**SUBMISSION TO THE DEPARTMENT OF PLANNING AND INFRASTRUCTURE ON THE PROPOSED
NORTH WEST RAIL LINK (NWRL)**

Application Number: SSI-5100

Figure 6.11 Cheltenham Services Facility light vehicle access and egress

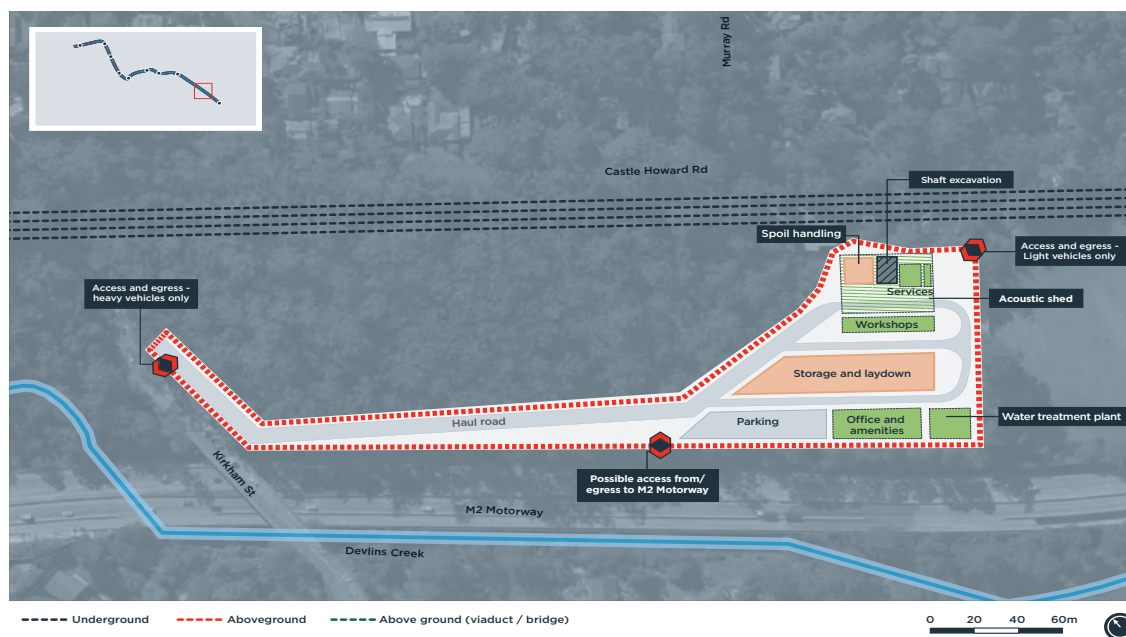
1. The option to construct a new two lane paved road through the Castle Howard Conservation Reserve to Kirkham Street (or Castle Howard Road) near the bridge over the M2 to allow trucks to remove spoil during construction and light vehicle access during operation of the facility will permanently destroy valuable Blackbutt Gully forest.

5. Should the roadway be built, the local streets (Kirkham Street, Castle Howard Road, Murray Farm Road and the bridge over the M2) are narrow, winding and congested and would not be suitable for trucks and, in the event of an emergency, large numbers of emergency vehicles.

I therefore ask that you adopt the alternative option of access to the site for construction and emergency vehicles be via new on and off ramps from the M2 motorway. The current widening and reinstatement of the breakdown lane should allow this access. It is the only practical way to move trucks in and out of the site. In the event of an emergency, many emergency vehicles would need quick access to the site from areas outside Beecroft and Cheltenham as it only has one fire engine.
